# CITY OF PORTLAND

Job ID: 2012-06-4358-CH OF USE

has permission to Demo existing structure, build new 3 story, 3 unit apt., 1 of 2 on Parcel A, single exit enclosure provided that the person or persons, firm or corporation accepting this permit shall comply with all of the provisions of the Statues of Maine and of the Ordinances of the City of Portland regulating the construction, maintenance and use of the buildings and structures, and of the application on file in the department.

**Jeanie Bourke - RE: 56 Hammond St BP#2012-06-4358 & 4359 plan review comments**

**A101**  
PERMIT SET  
5/18/2012

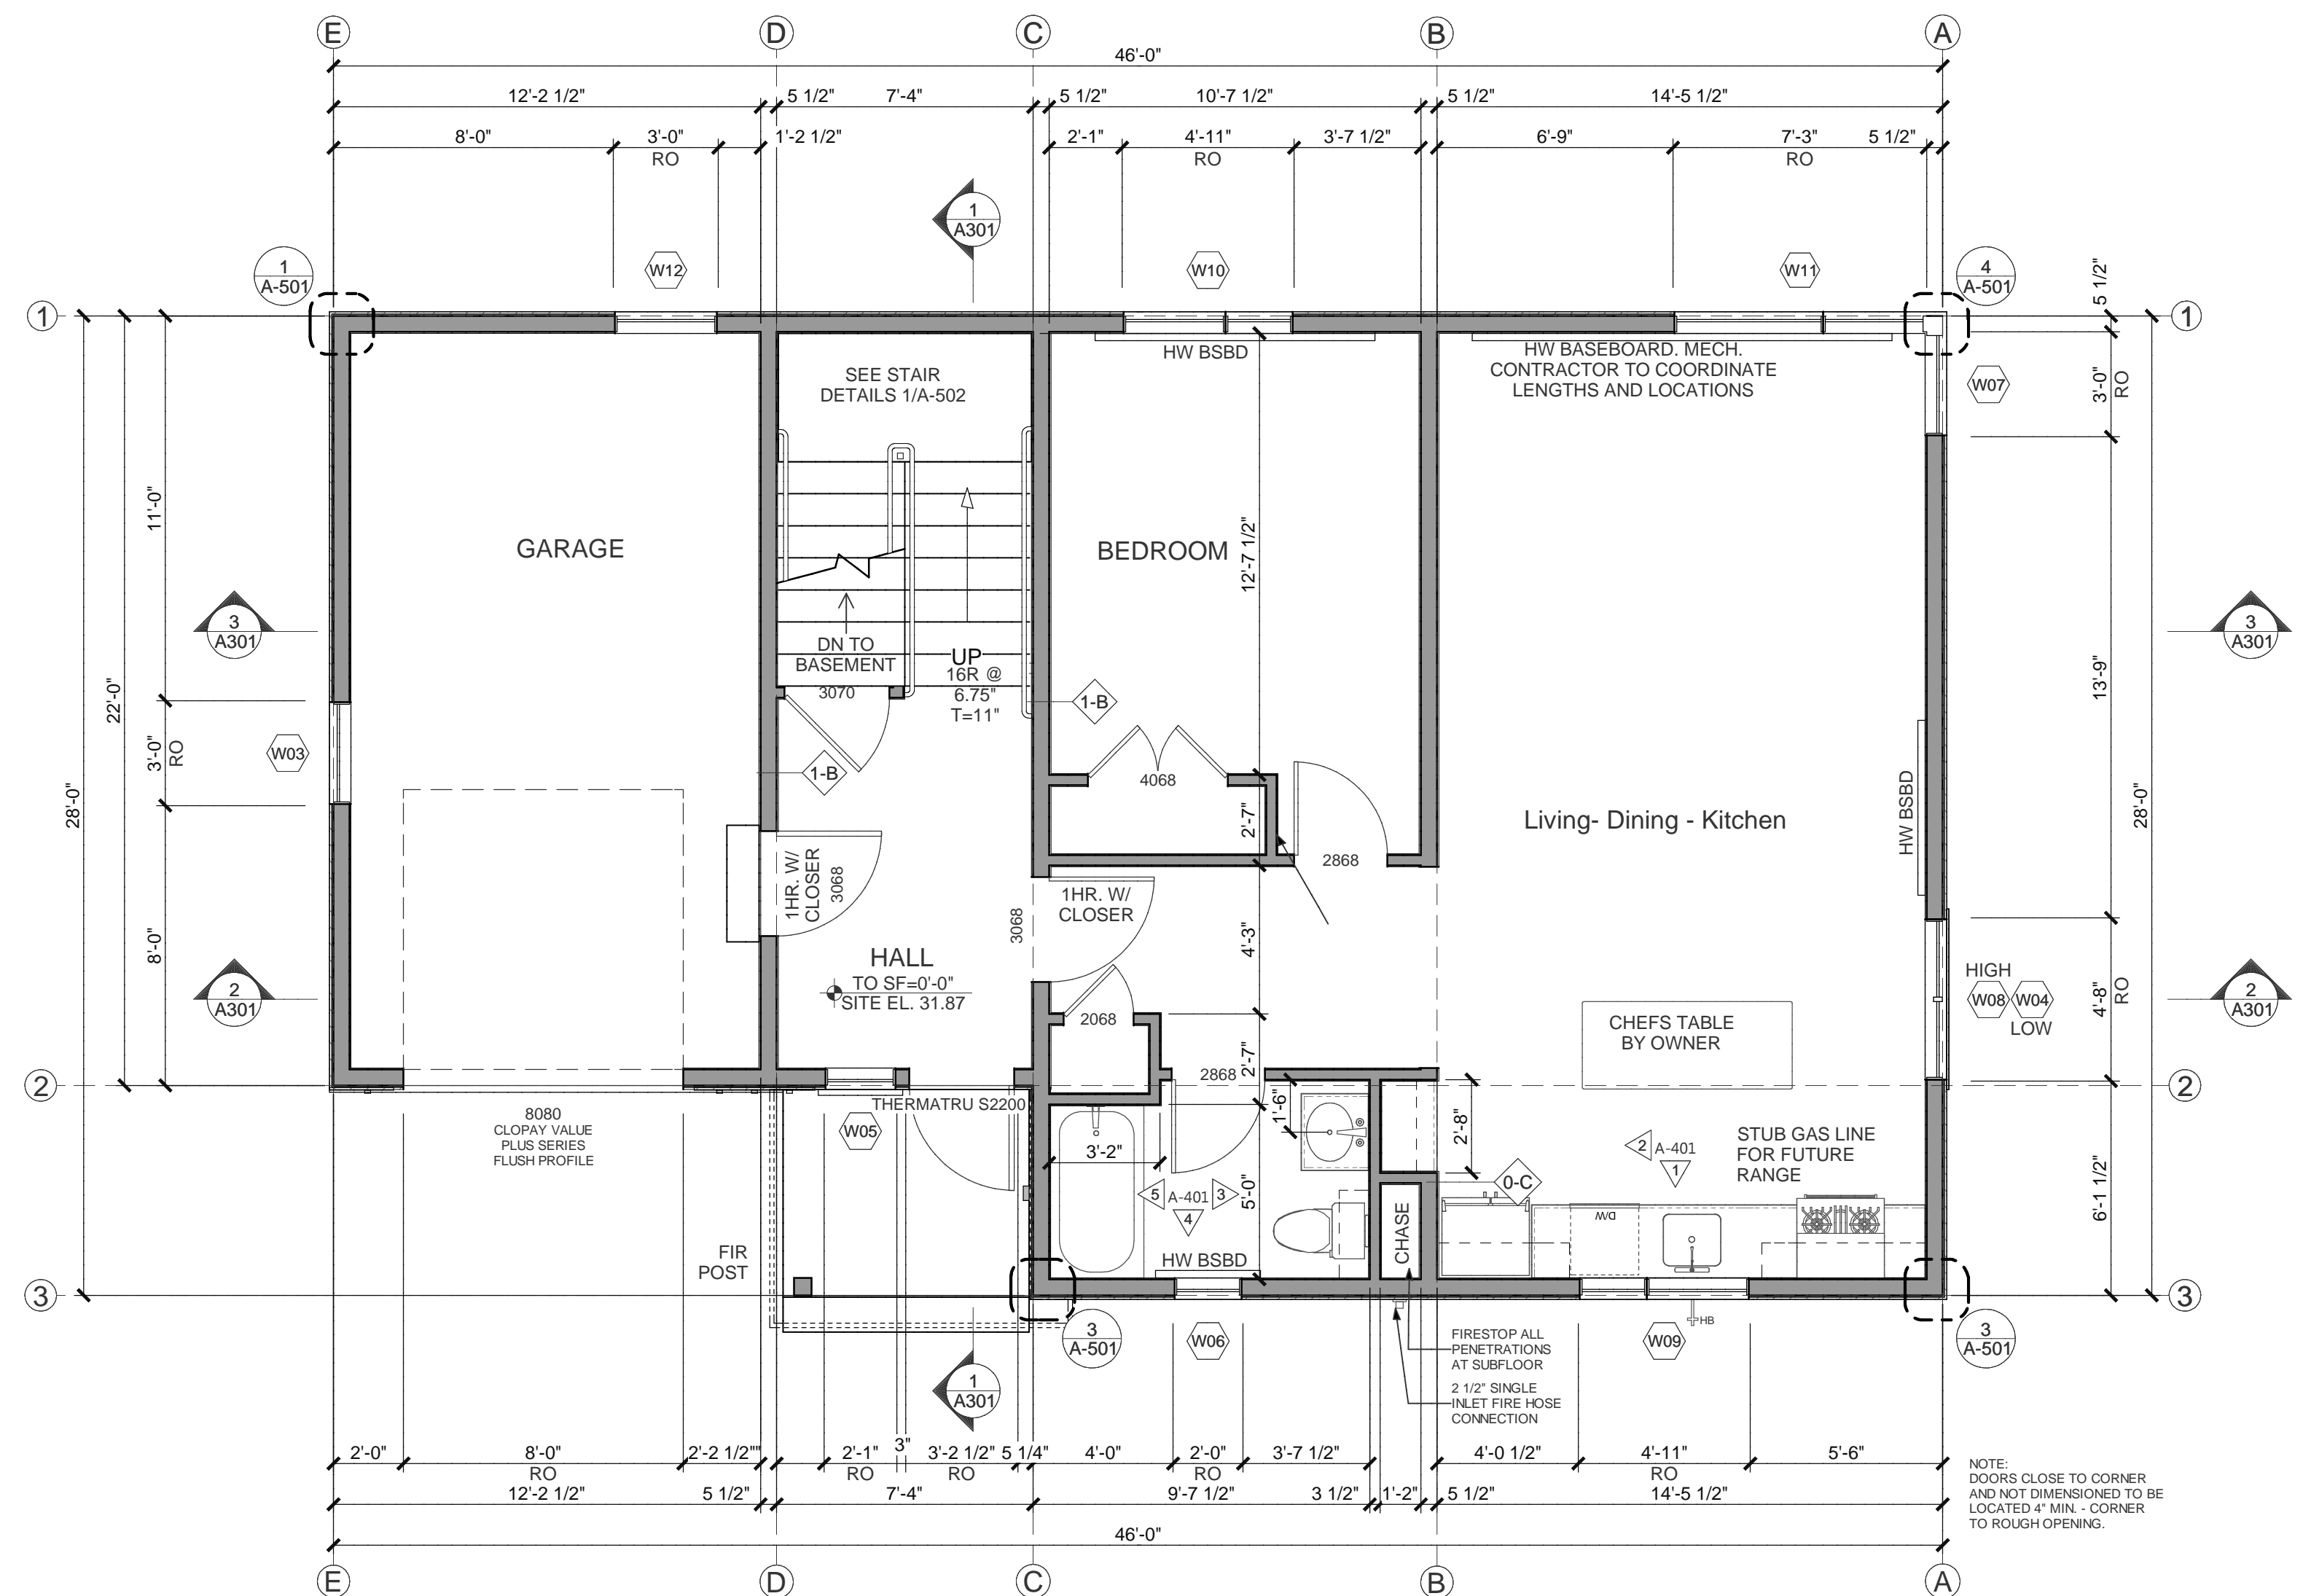
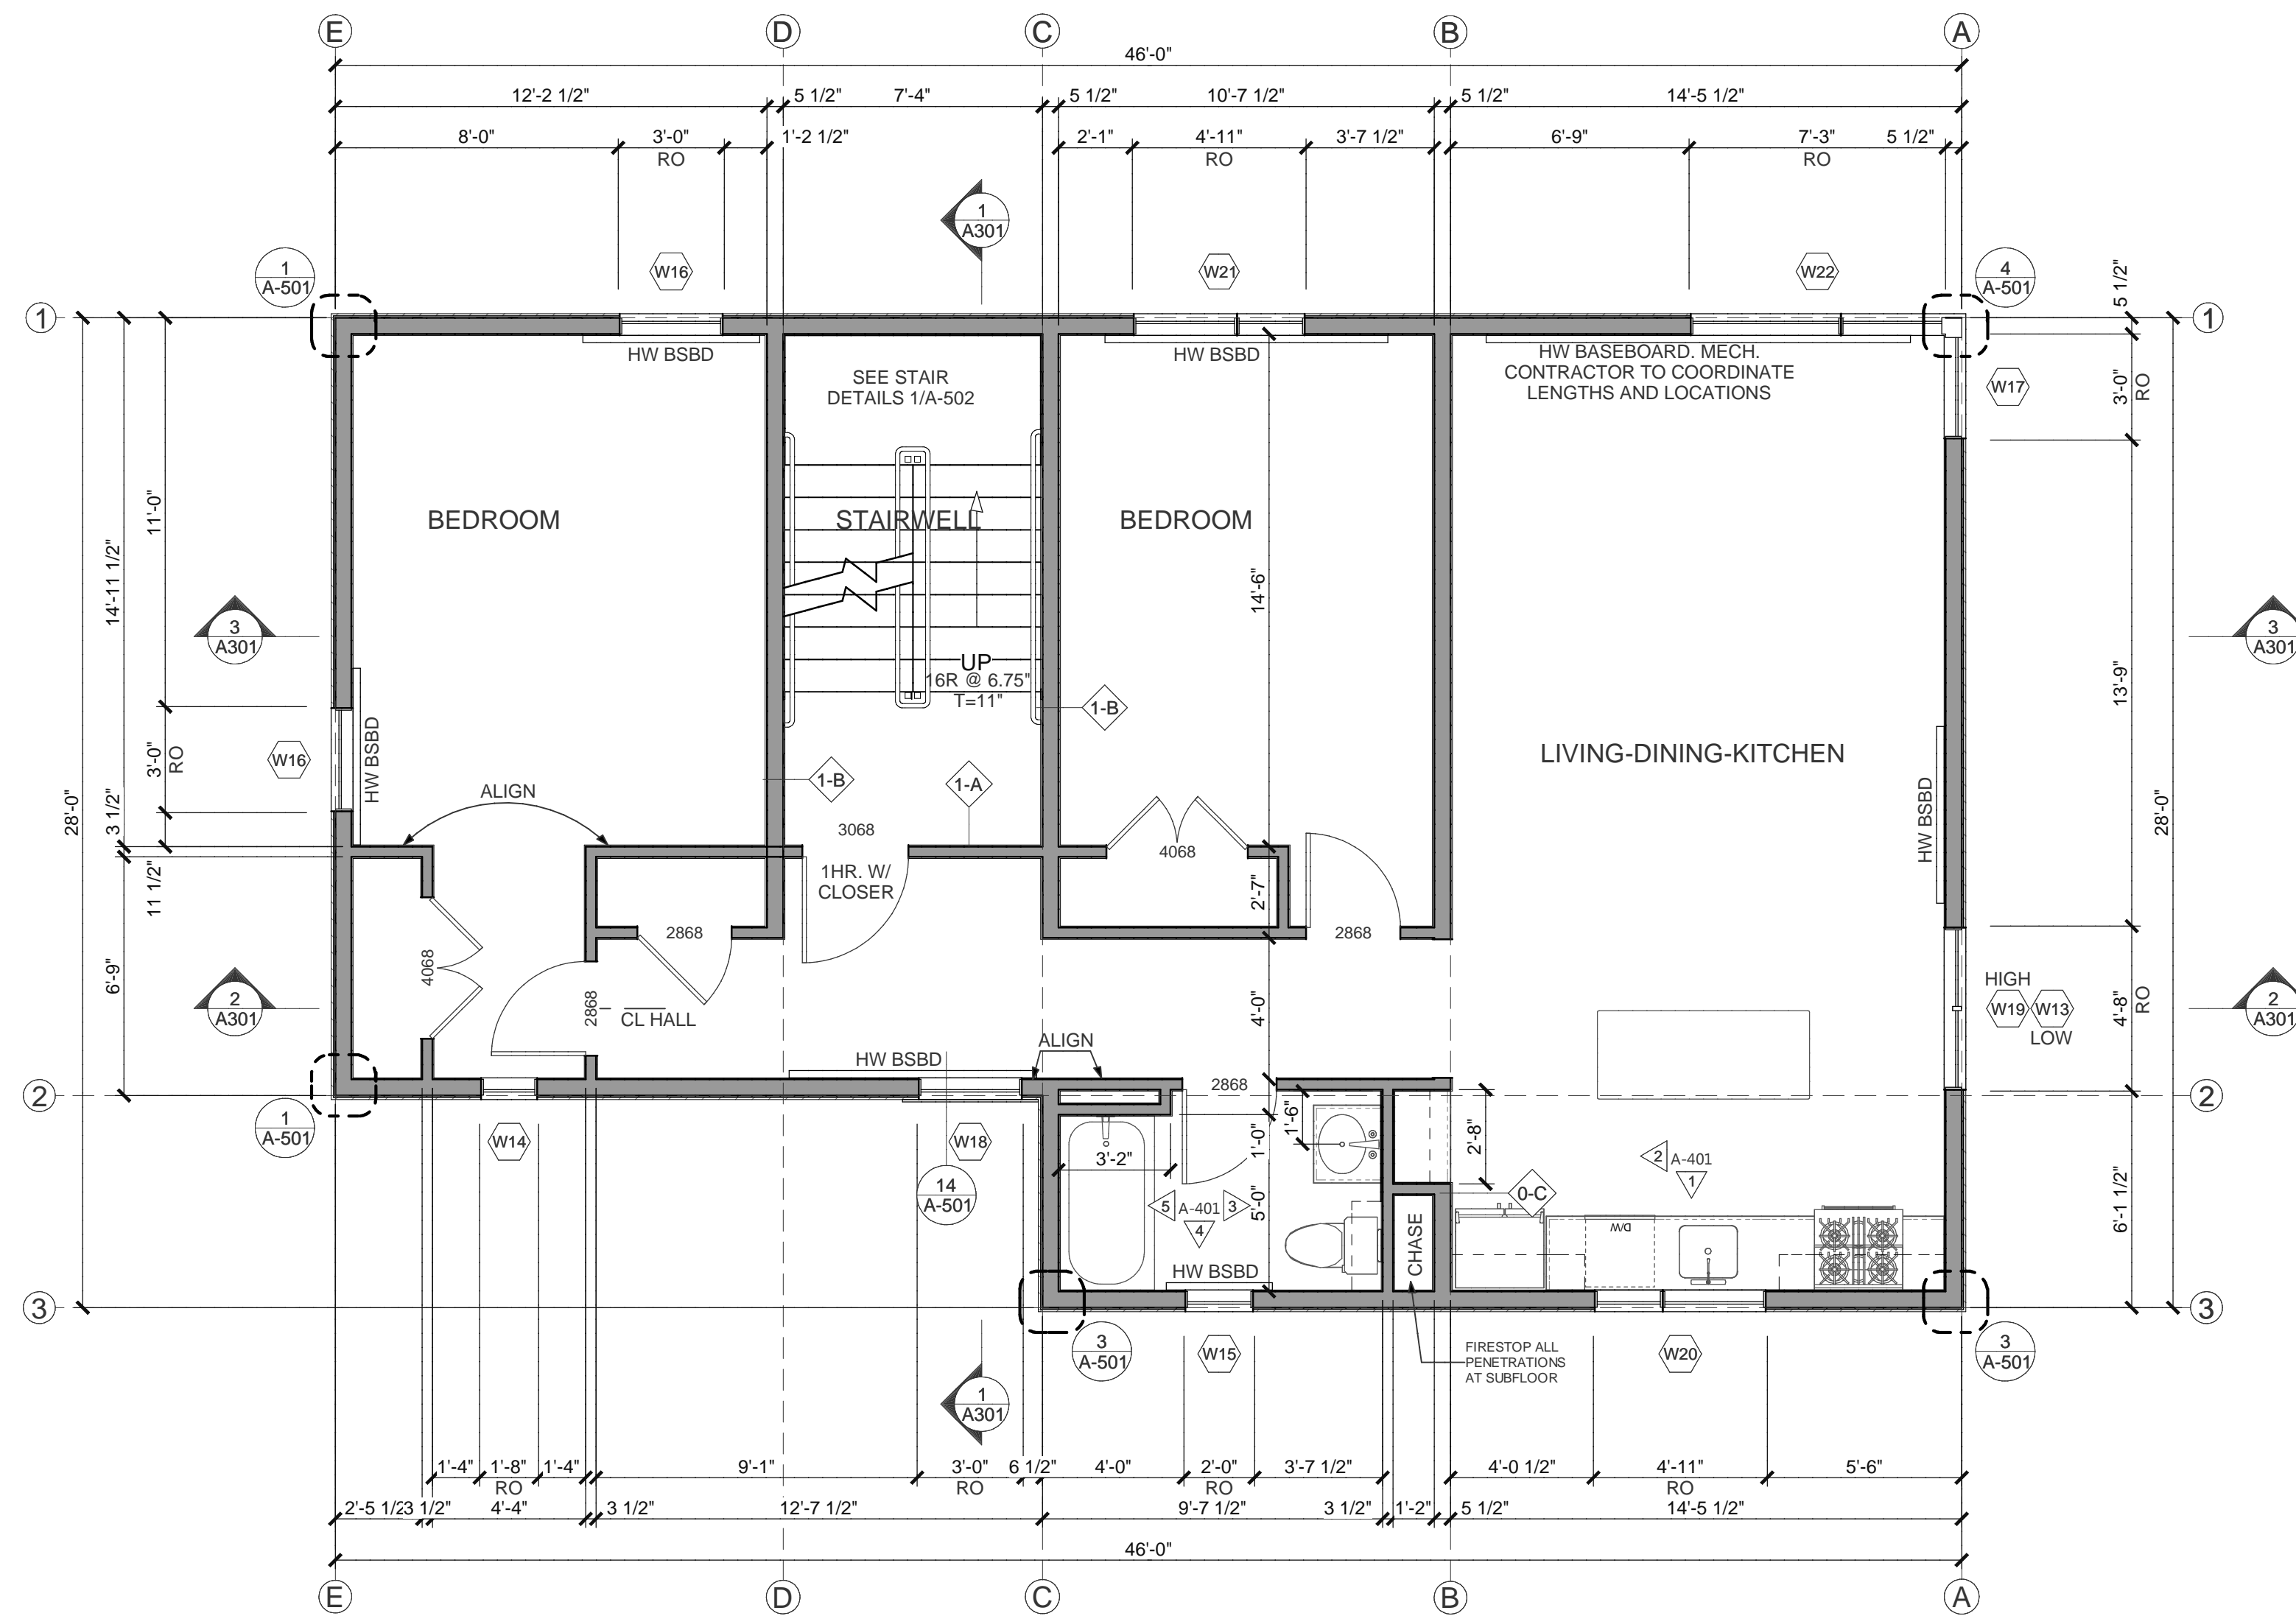
· Provide a 1 hour rated wall assembly for the mechanical chase 0-C or clarify if the penetrations are individual and sealed at each floor, thus not a true chase enclosure

*The penetrations are sealed at each floor. That is the intention of the note "FIRESTOP ALL PENETRATIONS AT SUBFLOOR" included on sheets A101 & A102.*
